From: T Stevens [REDACTED]
Sent: 08 November 2017 13:57
To: Zac Denton
Cc: [REDACTED]
Subject: RE: R/1/17/T

I have received Arboricultural comments regarding your application for works at various locations across the Poplars and Parklands Estates, Rustington.

BROOKEN BEE

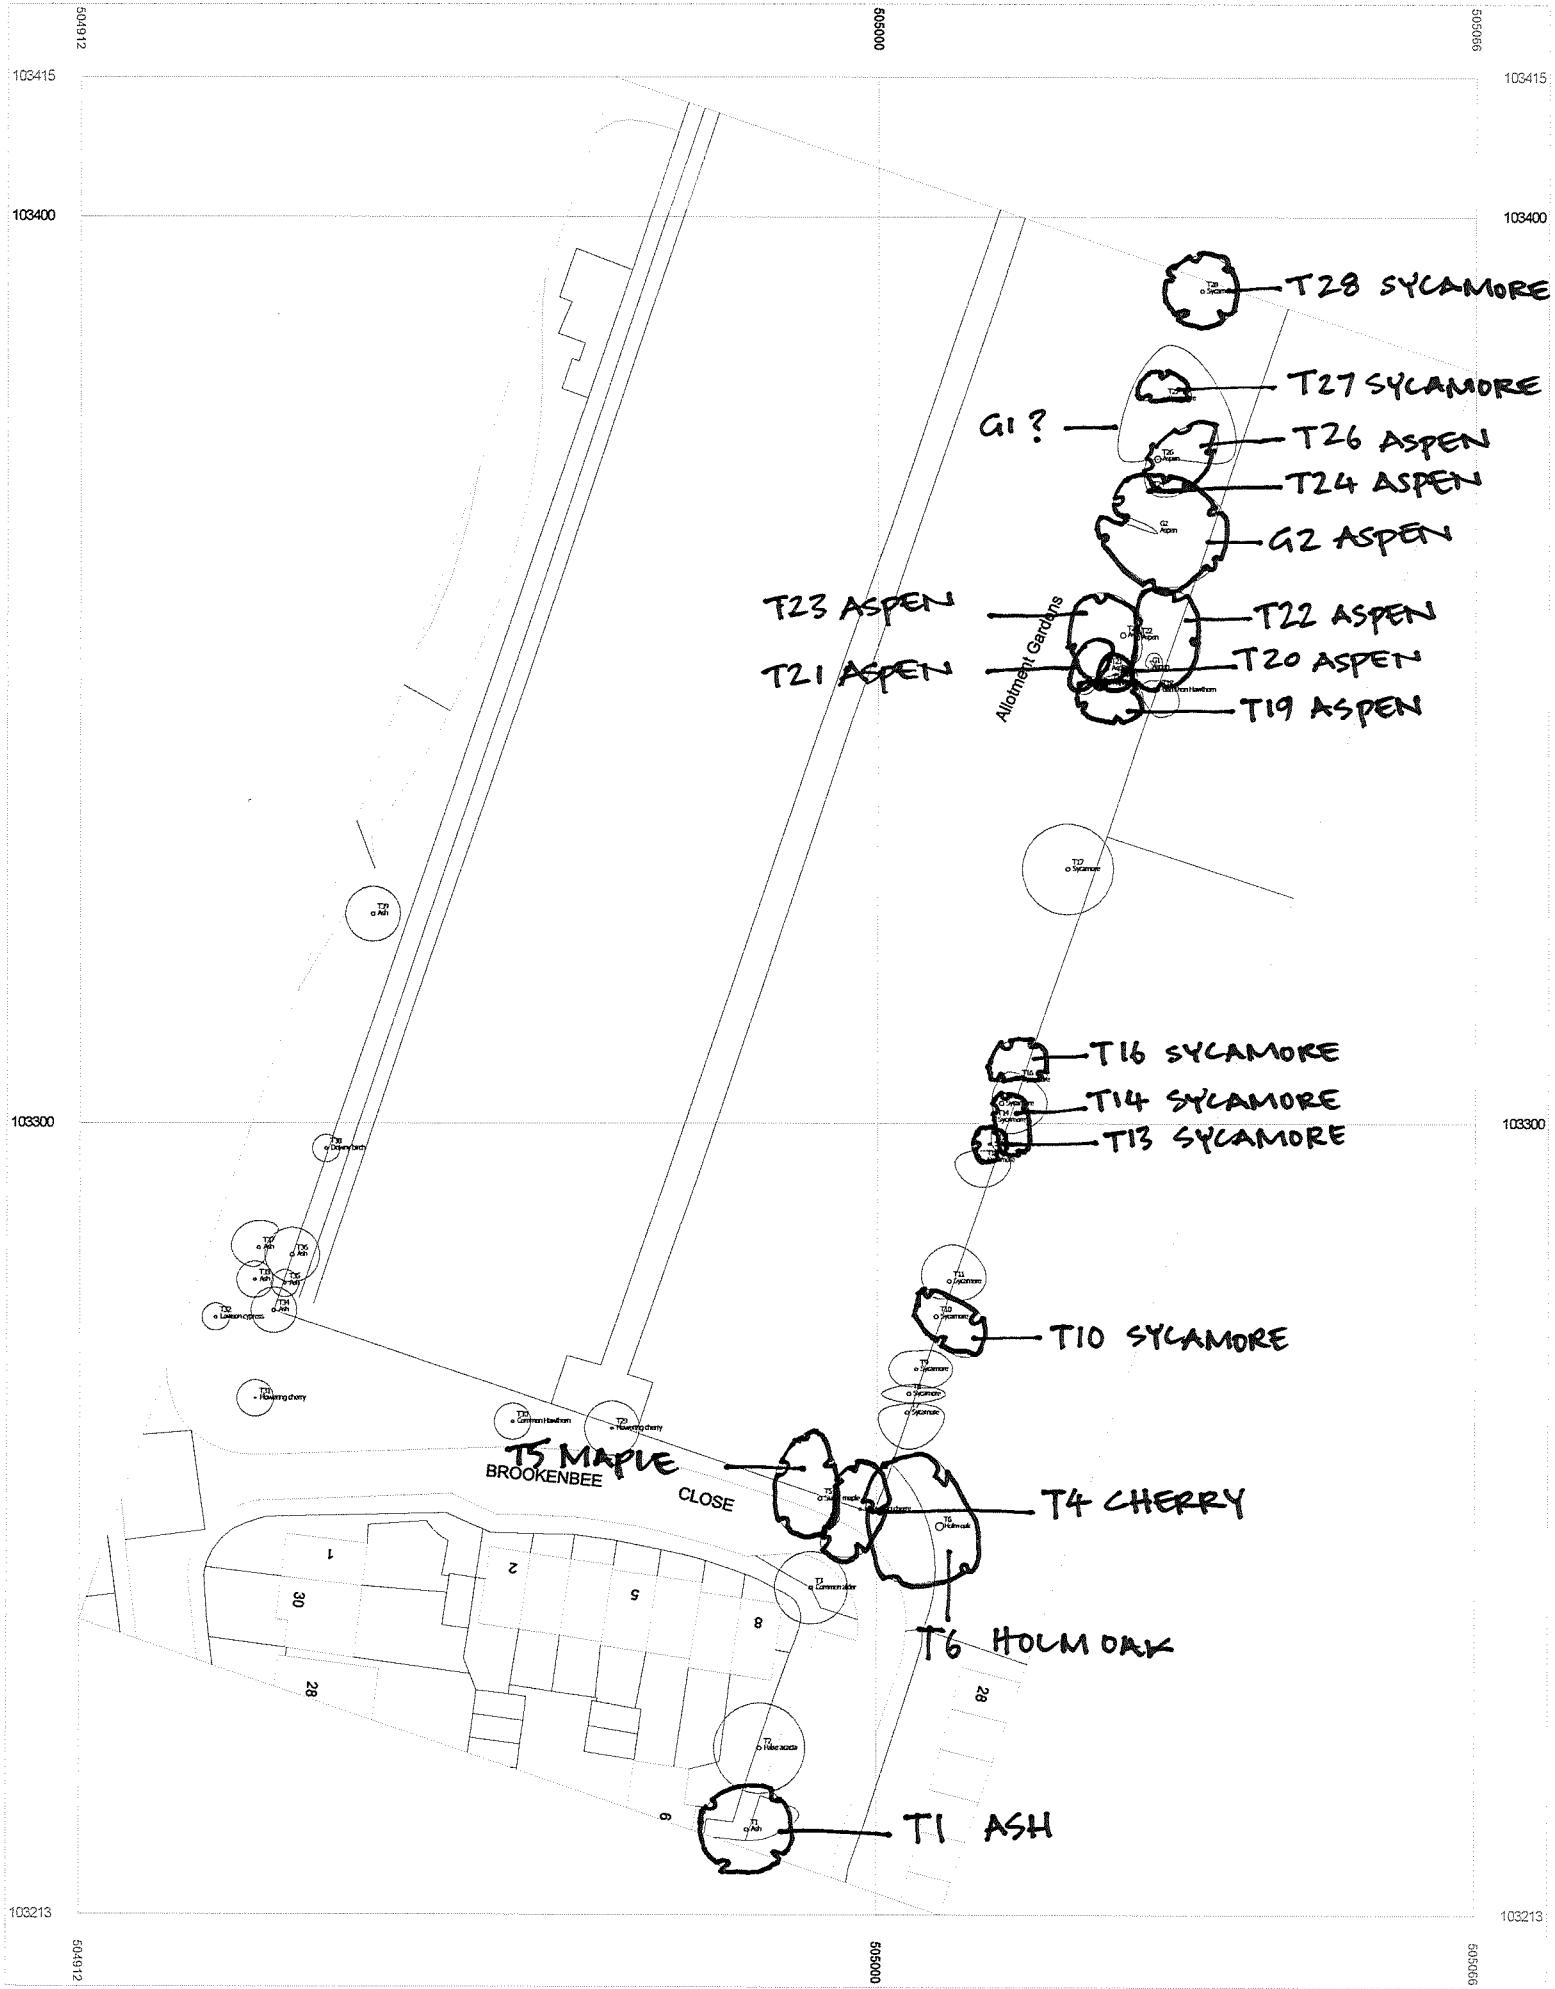
Please confirm that works to T16, T22, T23, T24, T26, T39 and T1 will no longer form part of the application, and will therefore require resubmission.

Many thanks for your email below – we have spoken with the tree surgeon who is advising us on this application and can confirm that we agree to the removal of the works detailed below. In due course we would request further information as to the objection to these works to assist us with any future applications.

PARKLAND HUTCHINSON SUMMERLY FOXES, - NORTH

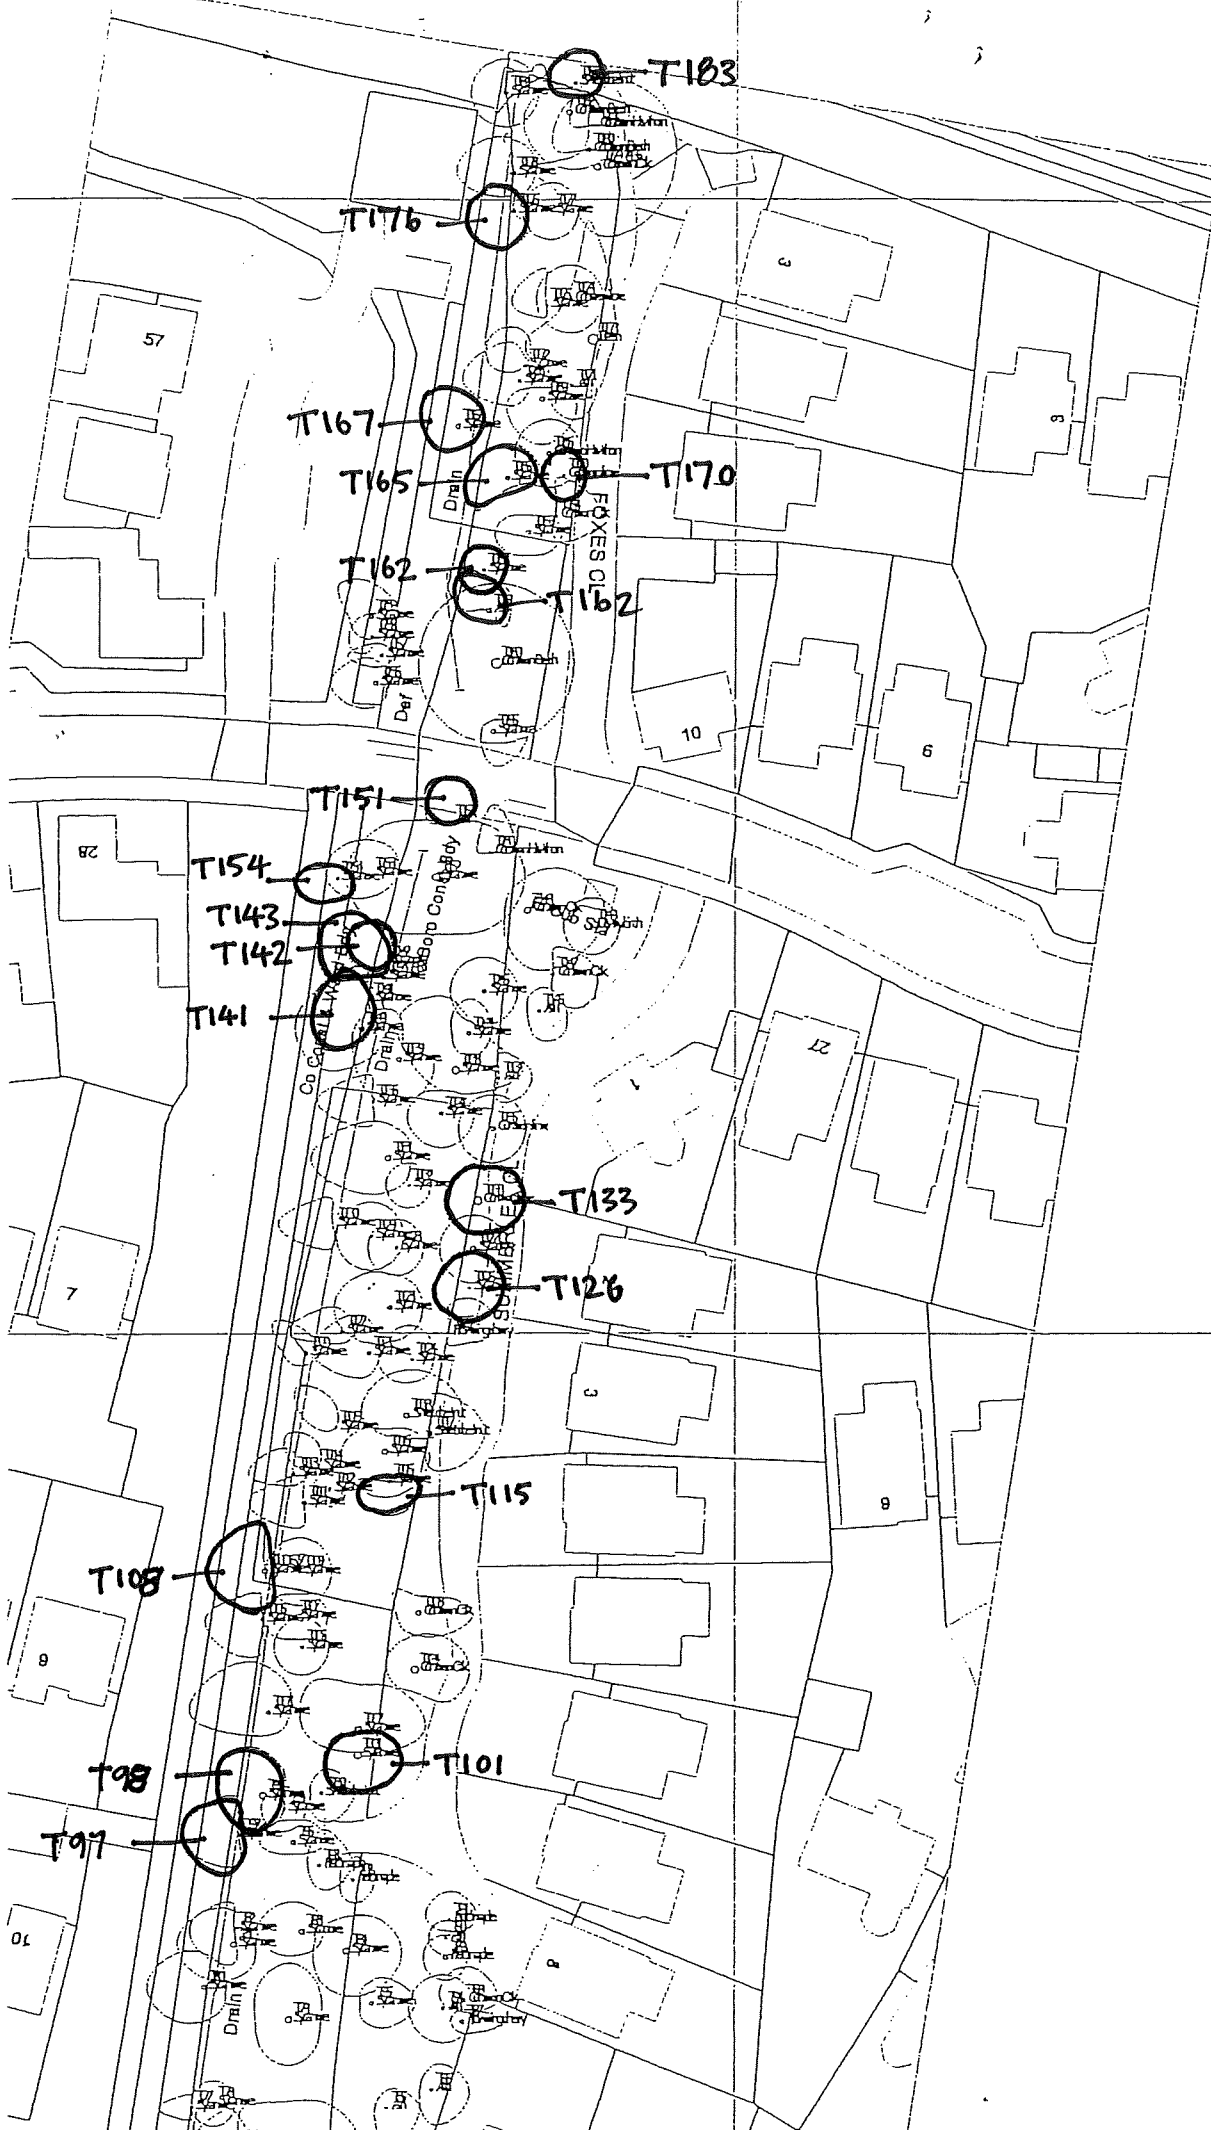
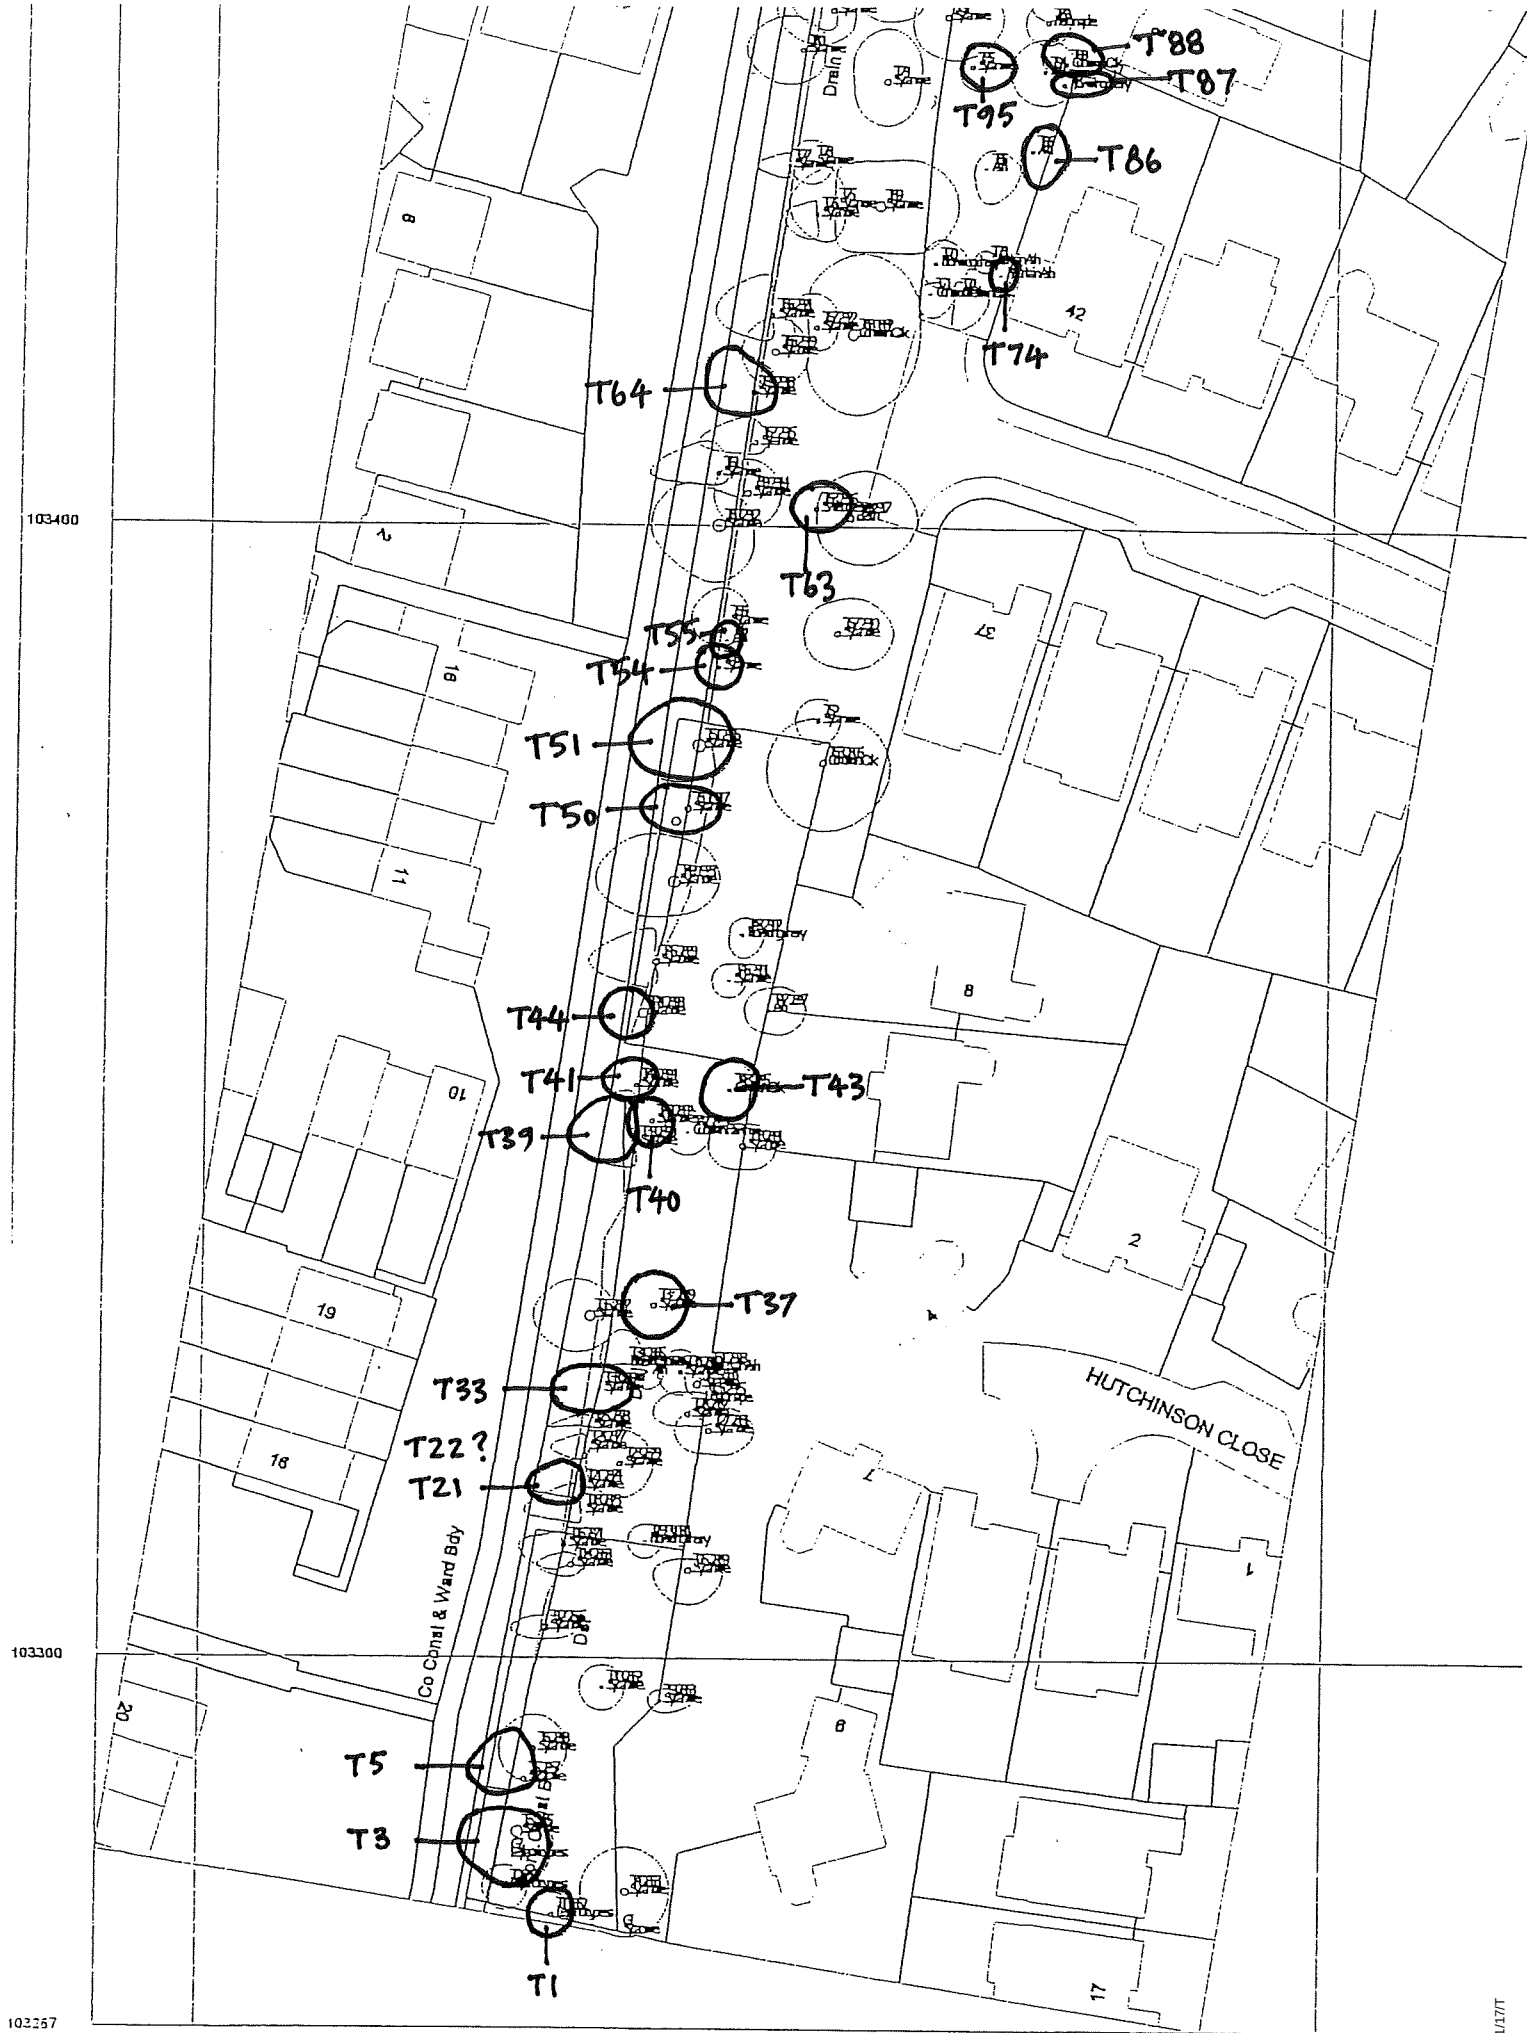
Please confirm that works to T5, T44, T141 and T160 will no longer form part of the application, and will therefore require resubmission.
